From: Amanda Scholes on behalf of Planning.Responses
Sent: 22 May 2018 08:39
To: Planning Scanning
Subject: FW: FAO Michael Eastham: Highways England response - A/40/18/OUT - Land North of Water Lane Angmering
Attachments: ITB9105-025A HE TA Clarifications.pdf; ITB9105-GA-024B.PDF; 20180521 - HEPR - A_40_18_OUT - Land North of Water Lane Angmering.pdf

Site: Land North of Water Lane, Angmering

Planning Application No: A/40/18/OUT

Highways England Planning Response (HEPR 16-01)

TITLE: PROPOSED IMPROVEMENT SCHEME TO A280 / A27 / TITNORE LANE ROUNDABOUT			
PROJECT: LAND SOUTH OF WATER LANE, ANGMERING		CLIENT: RYDON HOMES, GLEESON DEVELOPMENTS LTD

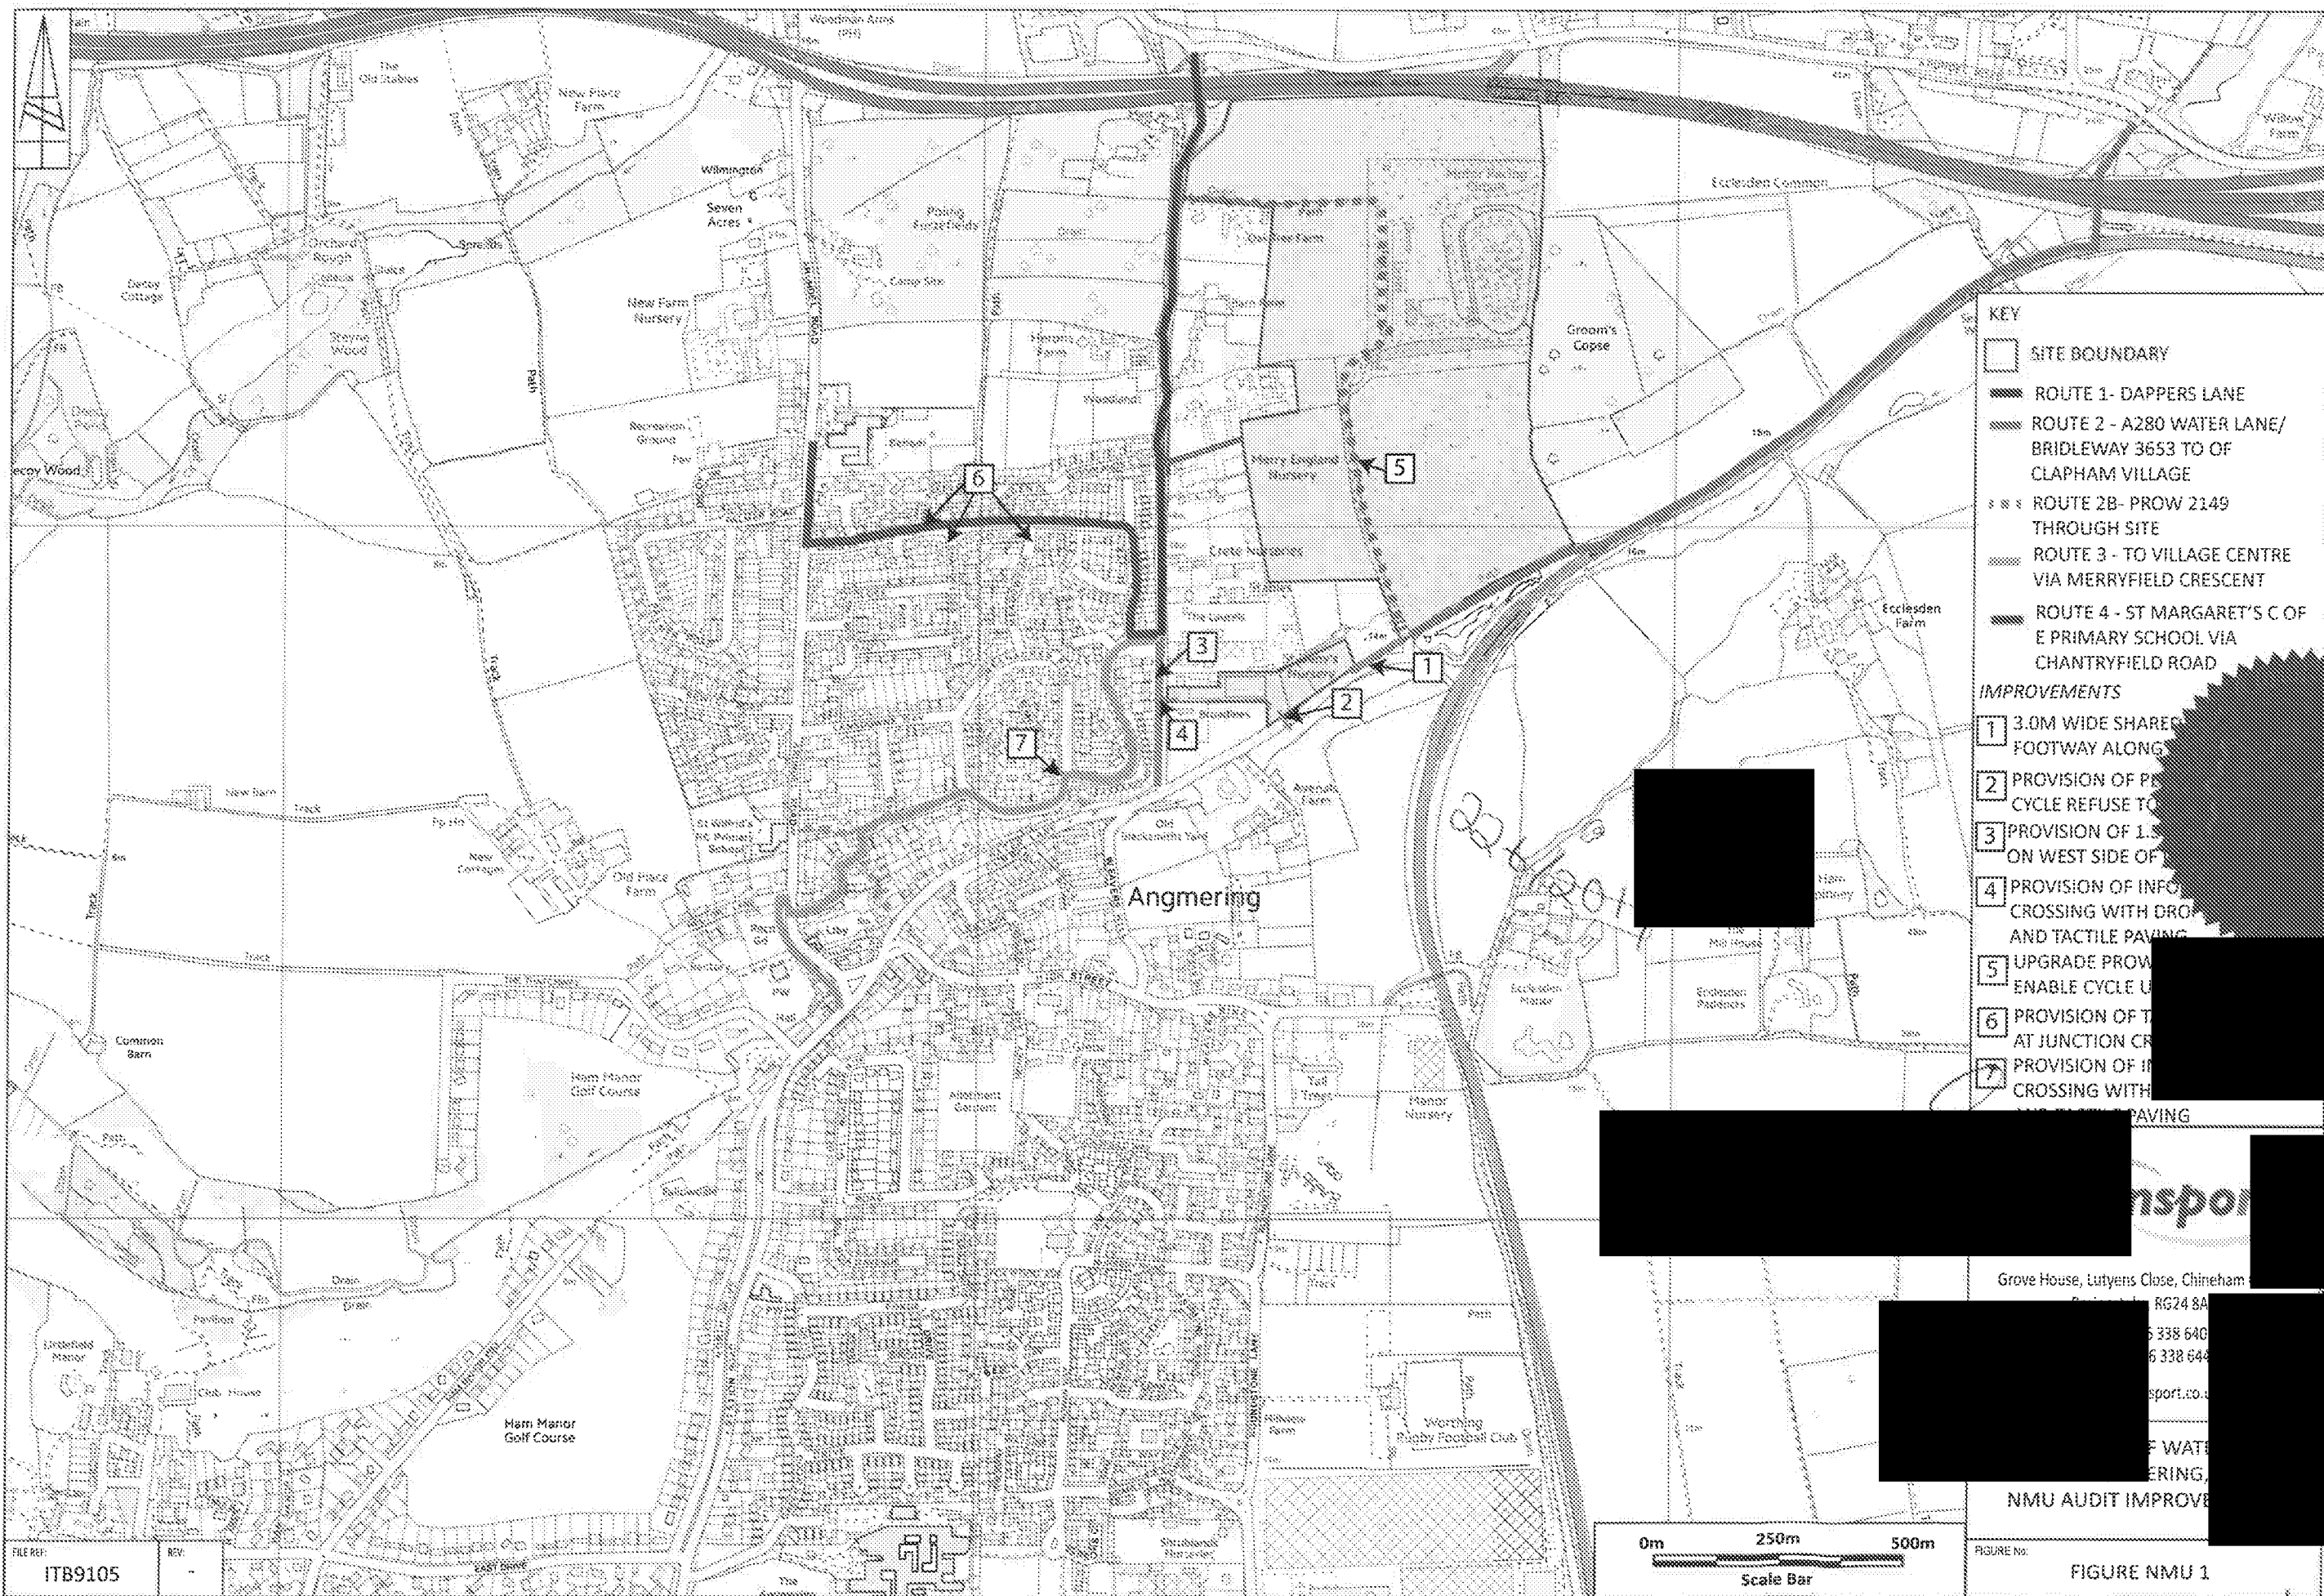
- 1) No part of the development hereby permitted shall be commenced until completion and opening to use of the highway improvement works as shown on i-Transport's drawing number "*ITB9105-GA-024 – Proposed Improvement Scheme to A280/A27/Titnore Lane Roundabout*" shown (or such other scheme of works substantially to the same effect, as may be approved in writing by the local planning authority (who shall consult with Highways England)), including any necessary transfer of lands to enable the construction and maintenance of the scheme.
